Laurclavagh Renewable
Energy Development

***AN COIMISIÚN PLEANÁLA
FURTHER INFORMATION
REQUEST***

Our Case Number: ABP-319307-24

Re: Proposed no 8 wind turbines and associated works.
Laurclavagh and adjacent townlands, Co. Galway. (www.laurclavaghplanning.com)

Figure 15-1 Site location and turbine delivery route

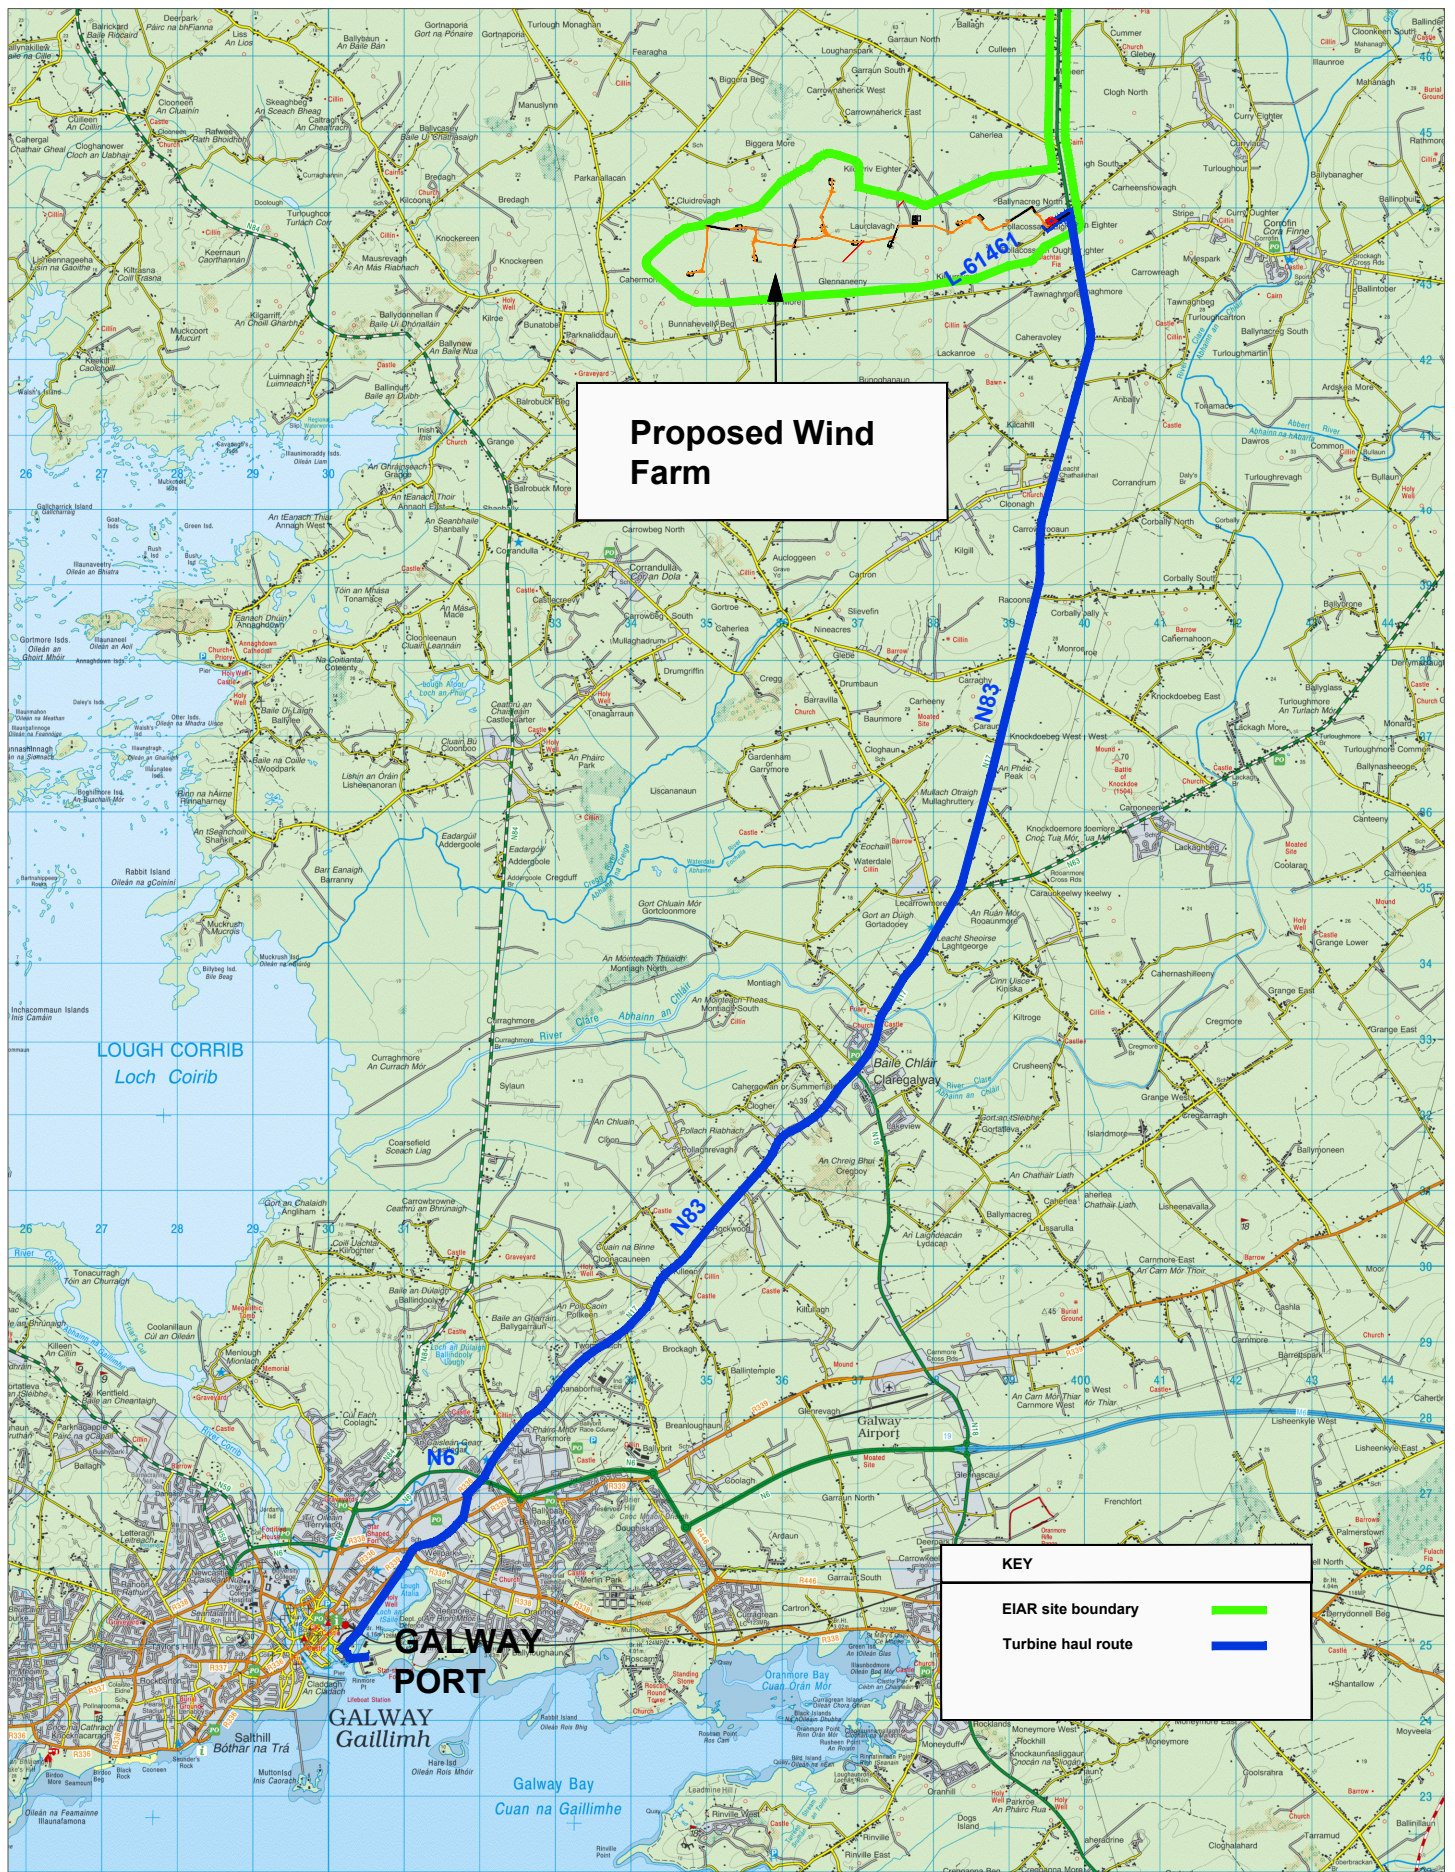
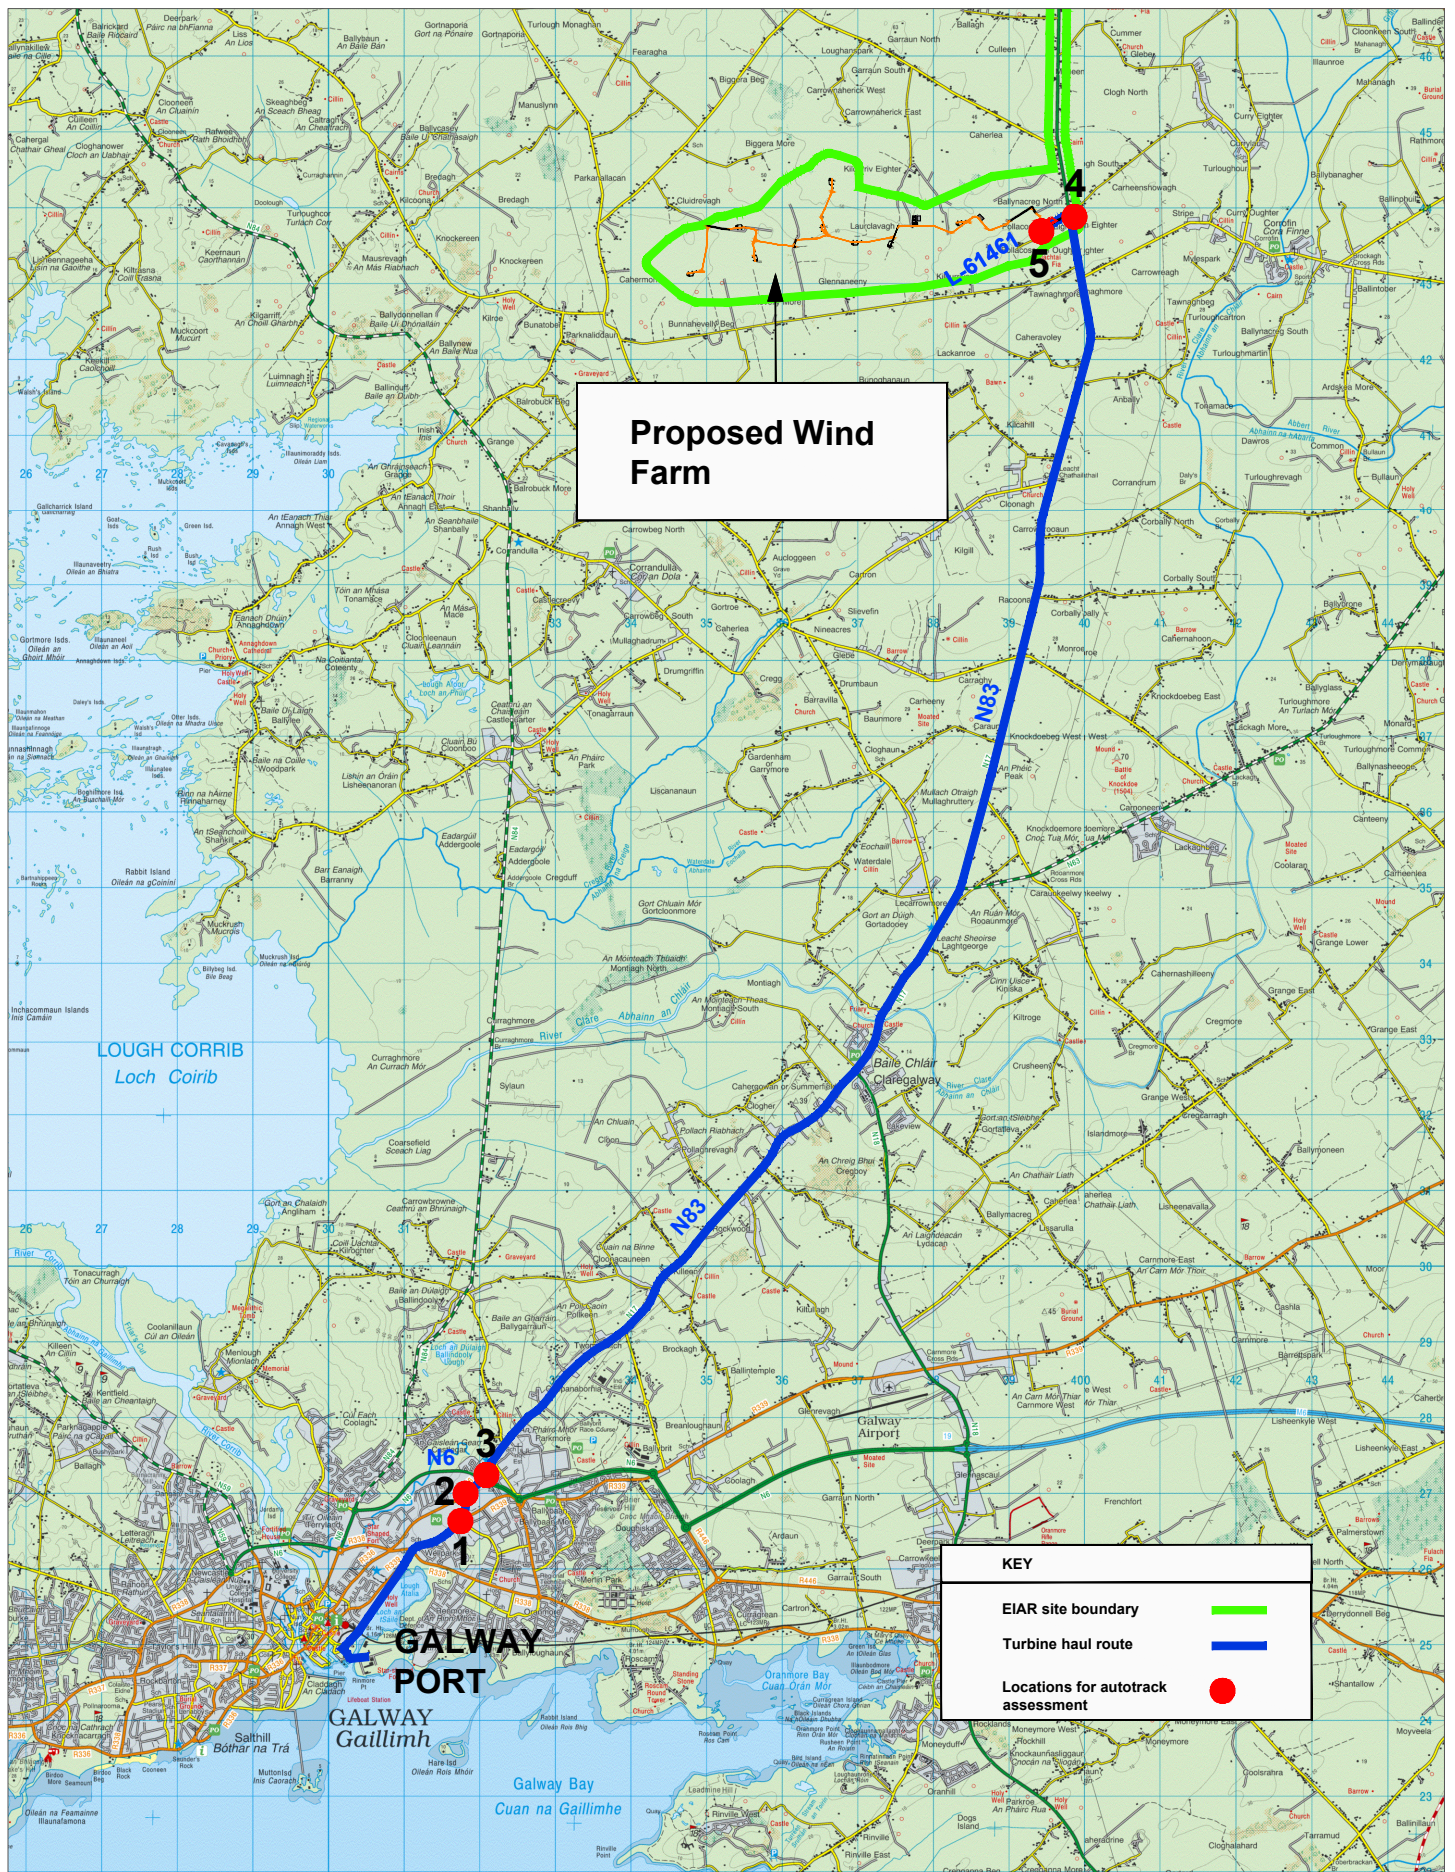
- 1.7 The details outlined on material assets in your response to submissions including the management of HGV trips on the L-61461, swept path analysis, new temporary access roads access and egress restrictions, and items raised in items 1.1, 1.2, 1.4 & 1.5 above should be included in an updated Road Safety Audit for the construction stage. This should be outlined by way of an addendum to the EIAR.
